City of Portland, Maine – Building or Use Permit Application 389 Congress Street, 04101, Tel: (207) 874-8703, FAX: 874-

Location of Construction: 24 Eastfield Rd		Owner: John J. Pallossi		Phone: 775-0520		Permit No: 980530	
Owner Address: 32 Wellington Rd Portland, ME 04102		Lessee/Buyer's Name:		Phone:		BusinessName:	
Contractor Name: Larry Pallossi		Address: 33 Meadow Ln Cumberland, ME 04021		Phone: 829-3654		Permit Issued: MAY 26 1998	
Past Use: Vacant Land		Proposed Use: 1-fam		COST OF WORK: \$		PERMIT FEE: \$ 140,000.00	
Proposed Project Description: Construct Single Family Dwelling w/attached 2 car garage		FIRE DEPT. <input type="checkbox"/> Approved <input type="checkbox"/> Denied		INSPECTION: Use Group: Type:		Zone: CBL: 194-C-058	
		Signature:		Signature:		Zoning Approval:	
Permit Taken By:		Date Applied For: 11 May 1998		PEDESTRIAN ACTIVITIES DISTRICT (P.A.D.) Action: Approved <input type="checkbox"/> Approved with Conditions: <input type="checkbox"/> Denied <input type="checkbox"/>		Special Zone or Reviews: <input type="checkbox"/> Shoreland <input type="checkbox"/> Wetland <input type="checkbox"/> Flood Zone <input type="checkbox"/> Subdivision <input type="checkbox"/>

TITLE: SITE PLAN
LOT 6
FROST STREET SUBDIVISION
EASTFIELD RD., PORTLAND, ME
SCALE: 1"=20'
DATE: MAY 8, 1998

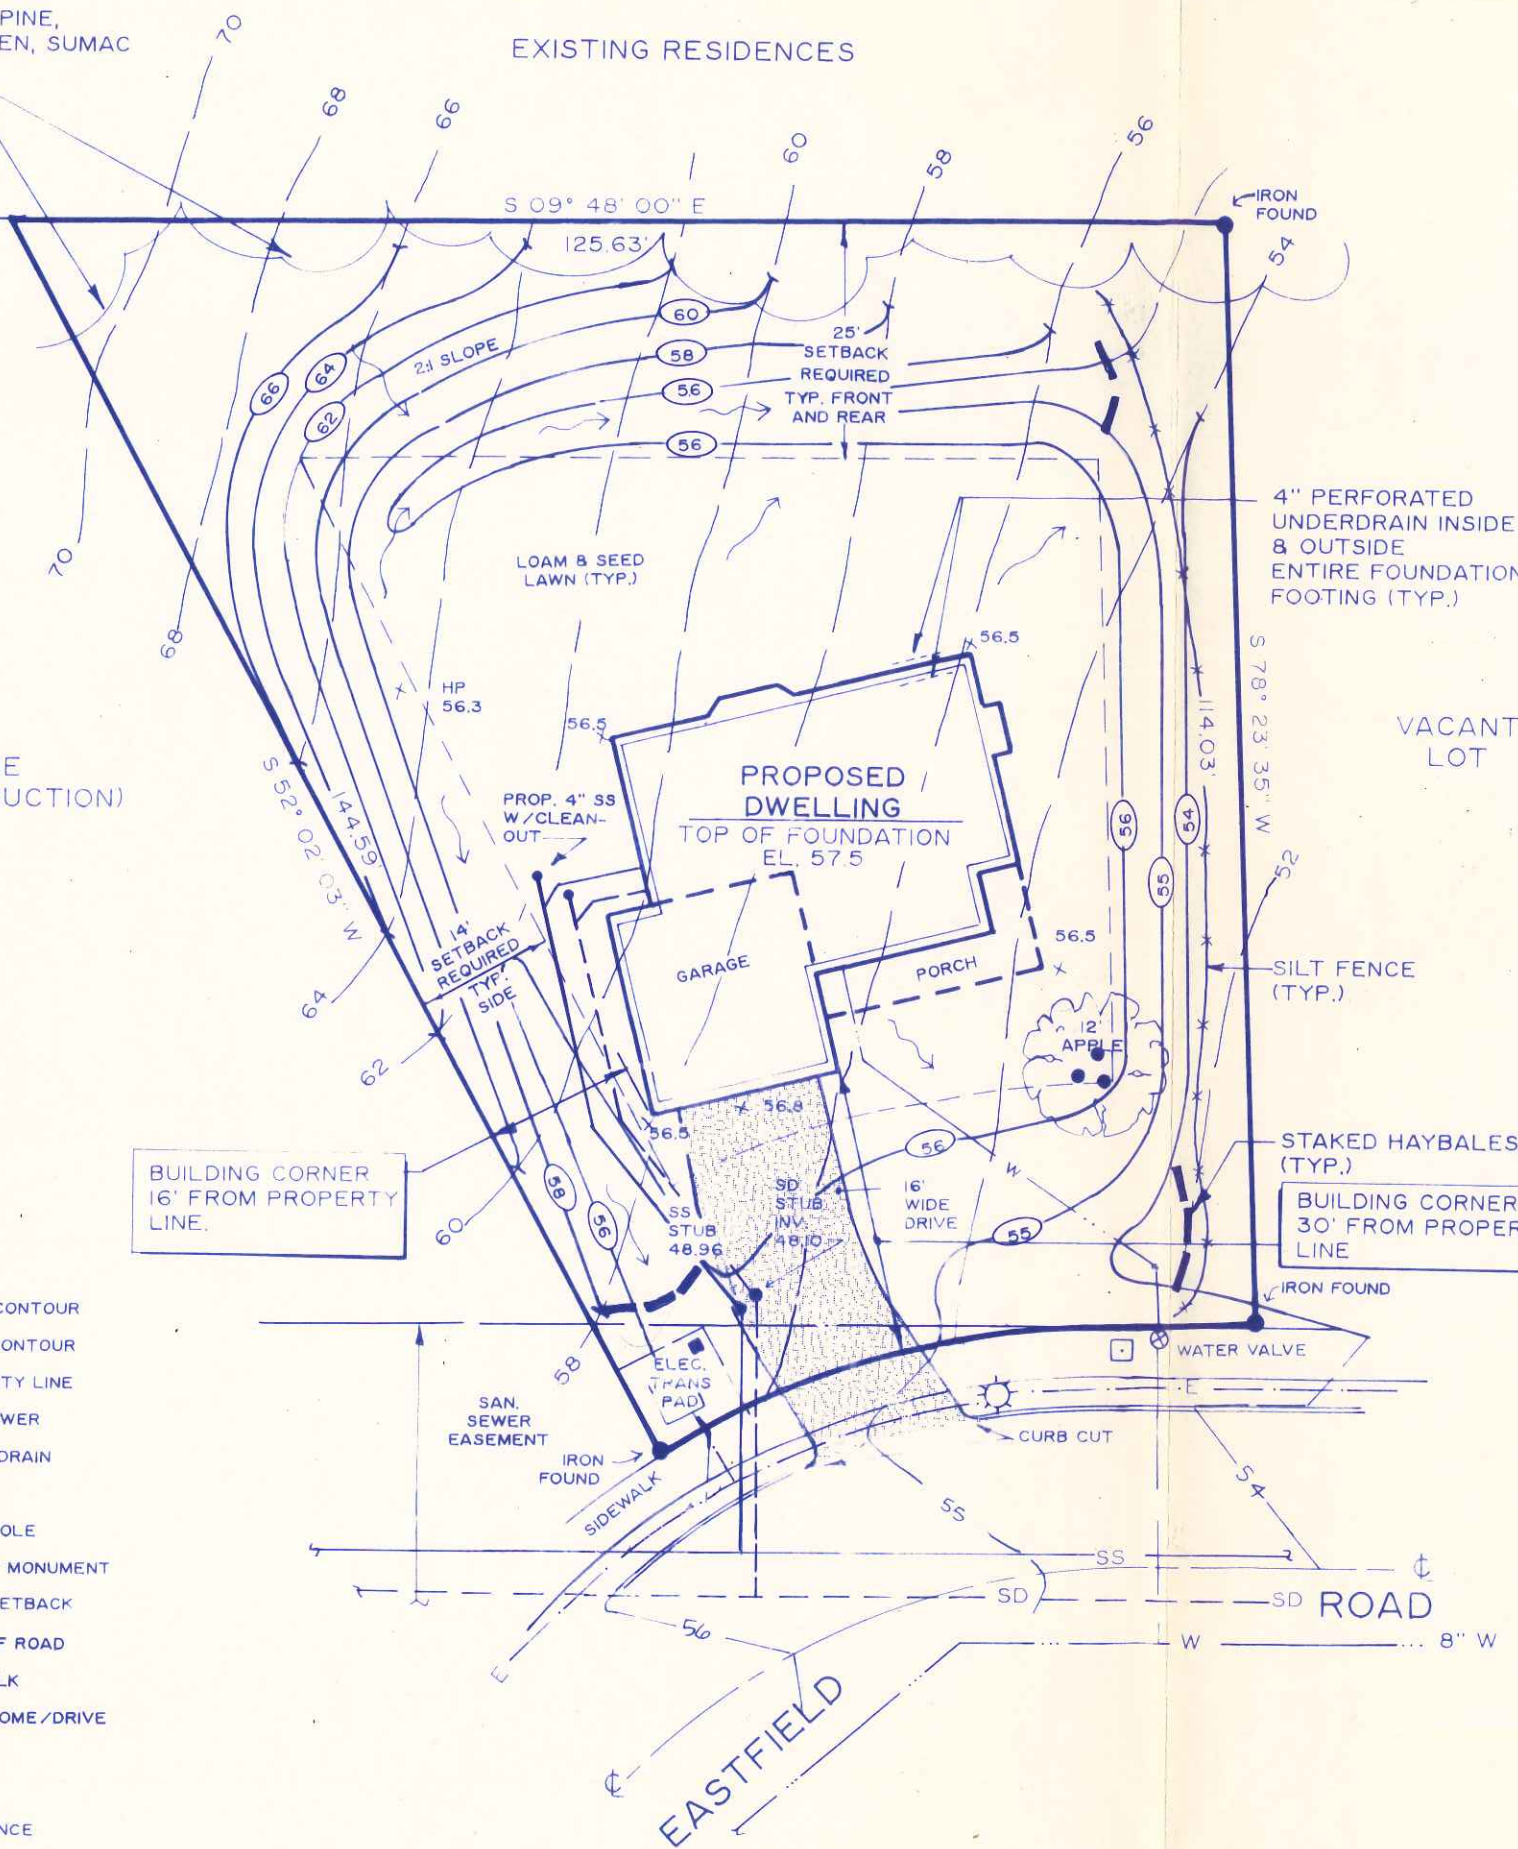
6/6/98 - Checked footing for Setback - Left of front Shows 16' on plan - actual is 15'; 14' allowed OK OK

Show all utility connections: water, sanitary, sewer, storm drain, electric, telephone, cable.

The site contractor shall establish finish grades at the foundation, bulkhead and basement windows to be in conformance with the first floor elevation (FFE) and sill elevation (SE) set by the building contractor to provide for positive drainage away from entire footprint of building.

A drainage plan shall be submitted to and approved by Development Review Coordinator showing first floor elevation (FFE), sill elevation (SE), finish street/curb elevation, lot grading, existing and proposed contours, drainage patterns and paths, drainage swales, grades at or near abutting property lines, erosion control devices and locations and outlets for drainage from the property.
